From: Nicola Spencer
Sent: 24 May 2019 10:34
To: Daun Johnson
Subject: FW: Further Information Required on Your Ref: PP-06776872 Our Ref: LU/87/19/HH

Thank you for providing the fee and biodiversity statement. However the plans you have provided are still not correct. The following need to be resolved

LOCATION PLAN

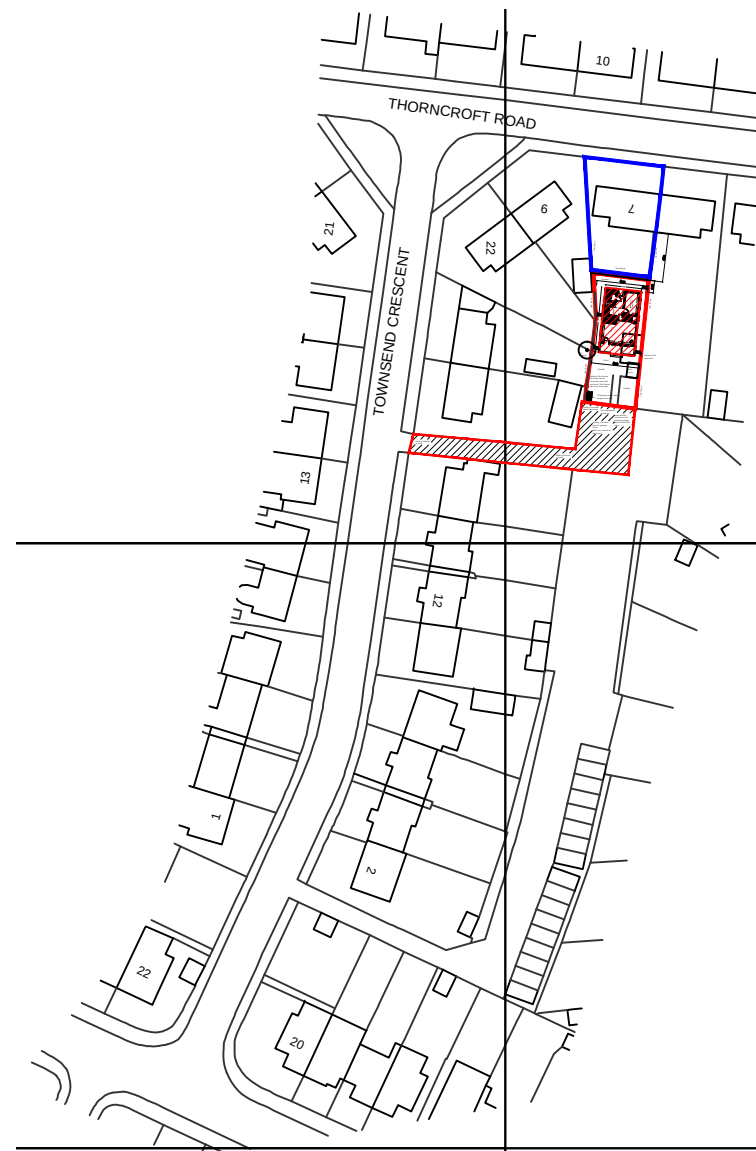
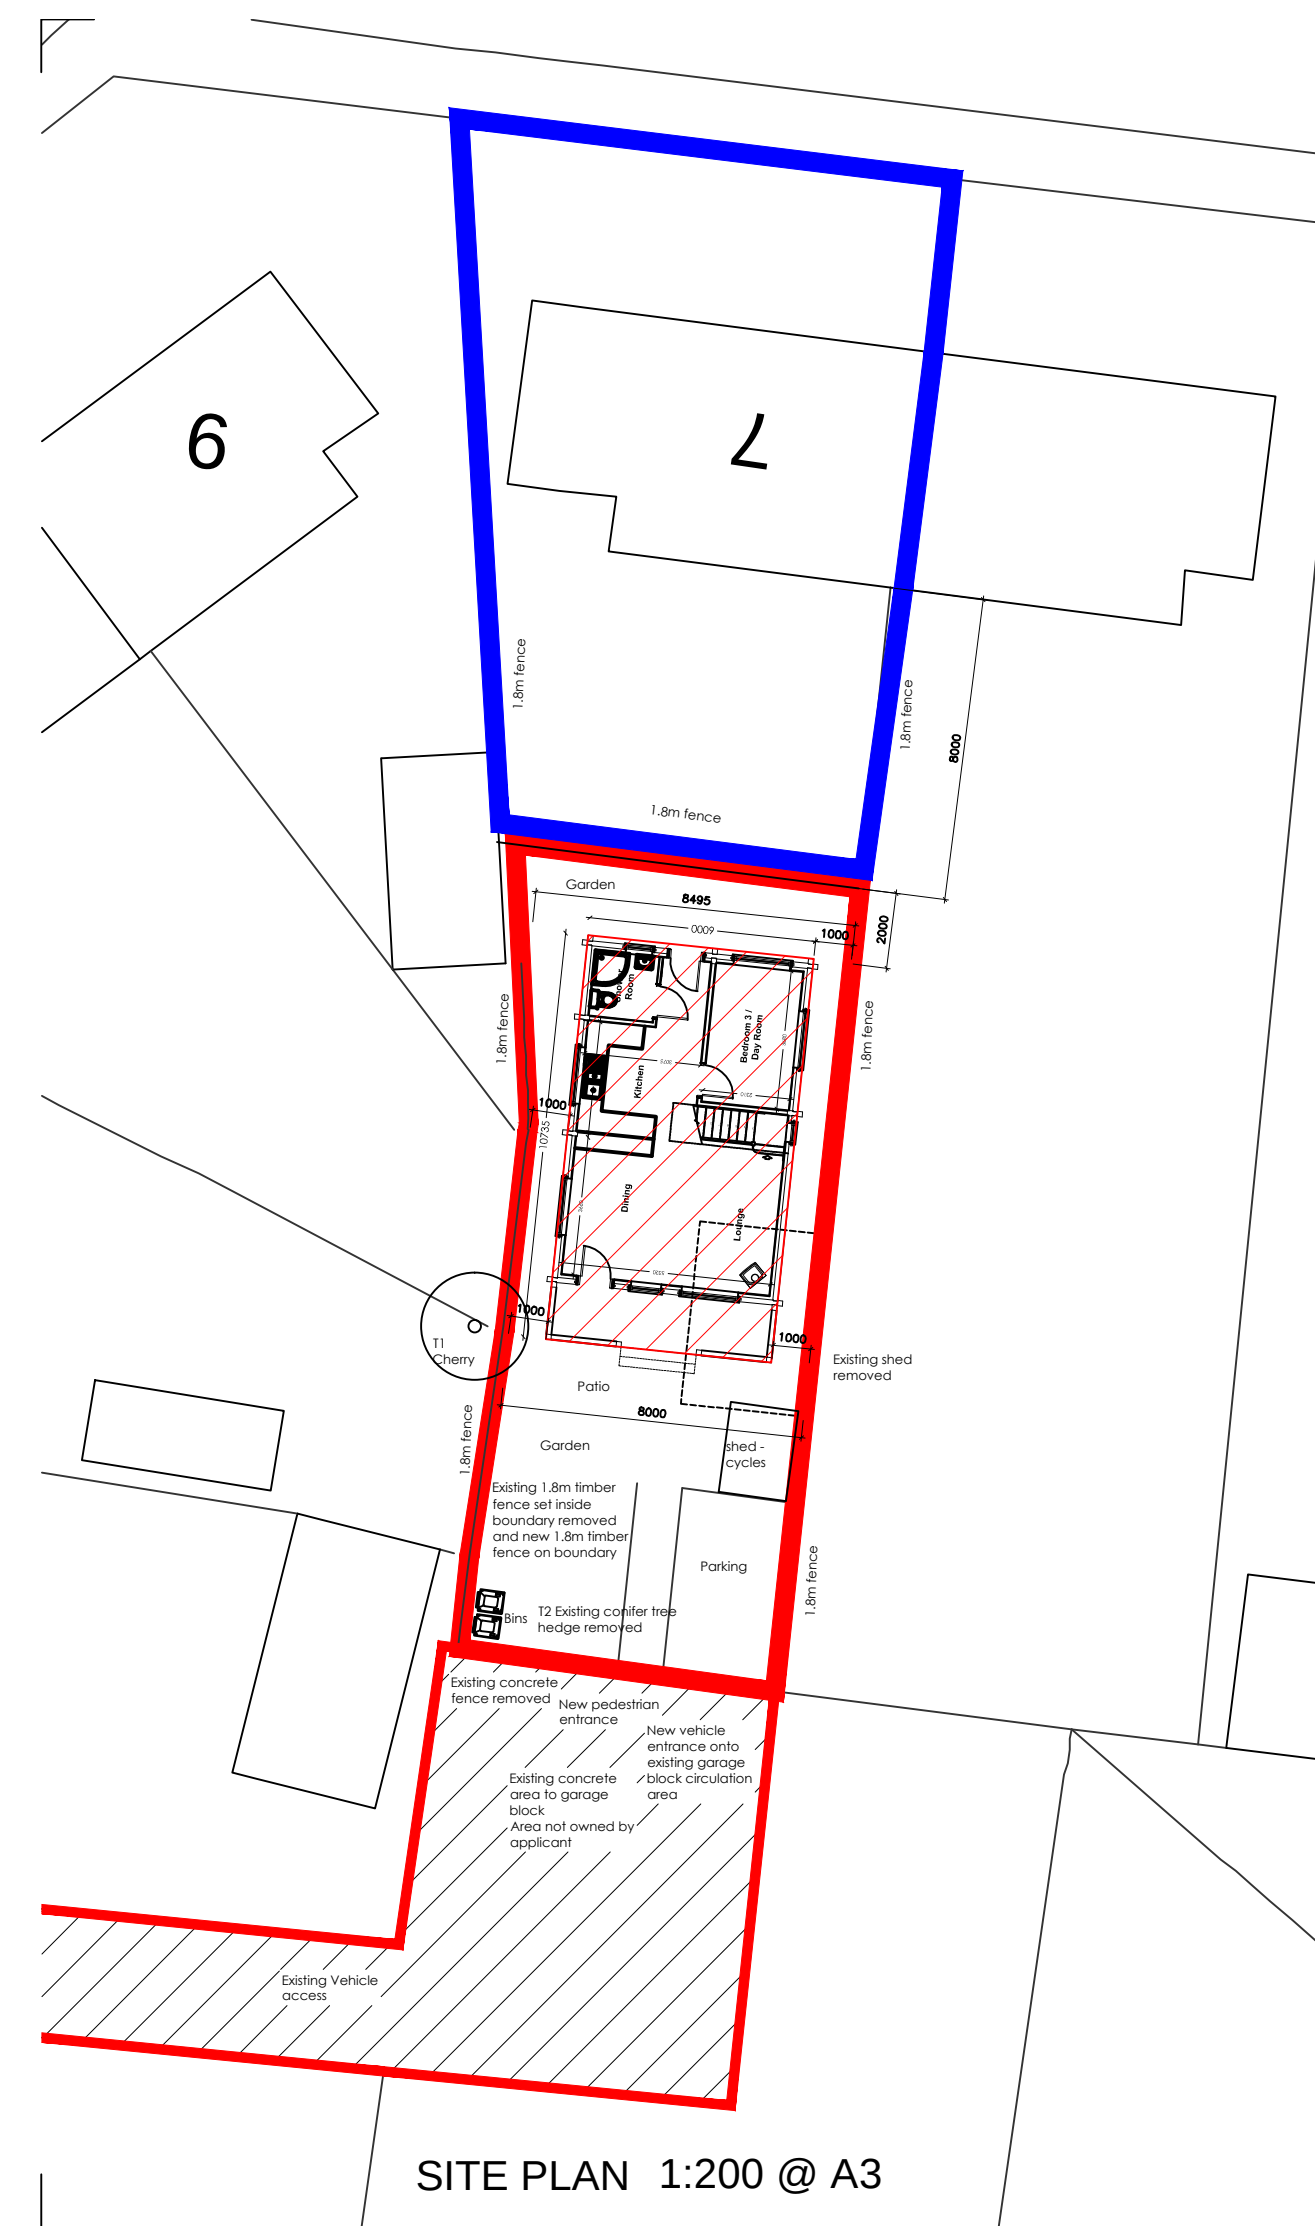
1. I am not sure if you are aware but all the plans you submit will form part of the planning permission if it is approved and you will have to build exactly to the plans. You have only roughly drawn the new dwelling and red and blue edges these need to be accurately drawn as we will measure from these plans.

2. The blue edge needs to be drawn onto the Location plan (1:1250 scale) not the block plan, (1:500 scale)
3. I am sorry but the access you have indicated is not correct. Basically the red edge would need to be extended to be around the area you have shown as hatched as the red edge must go up to the public highway. It is fine to hatch it to indicate it is the access, but it must be within the red edge and there should be a key indicating that the hatching relates to the access and indicate whether it is a vehicular or pedestrian access. If vehicular you will also need to show visibility splays which must also be incorporated into the red edge. If you require guidance on visibility splays you will need to contact West Sussex County Council Highways. The only contact name I have for this is

BLOCK PLAN

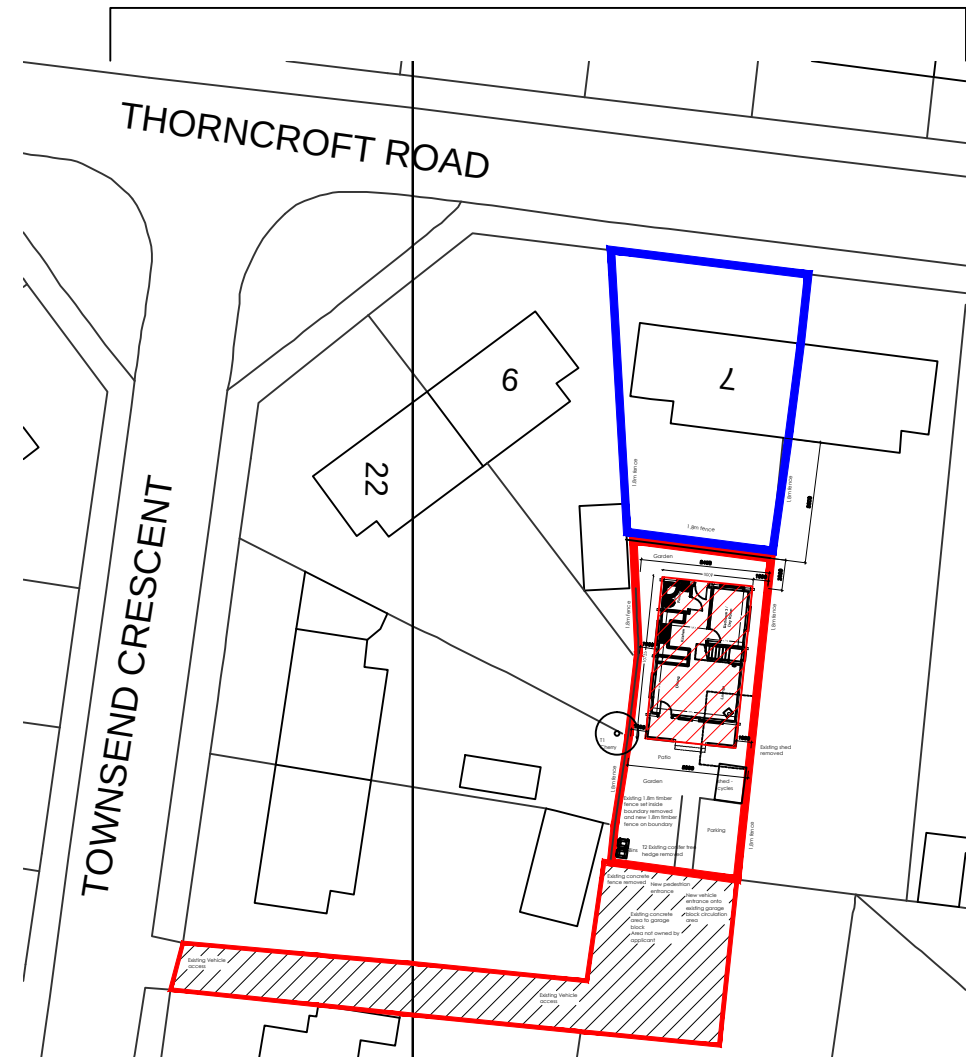
4. From the block plan it would appear that the visibility splays would encroach onto the properties either side of the drive way to the garage compound so you will need to complete Certificate B on the application form and return it to me and serve notice to both properties. I attach a certificate for you to complete and a notice form which you can use to serve on the other landowners.
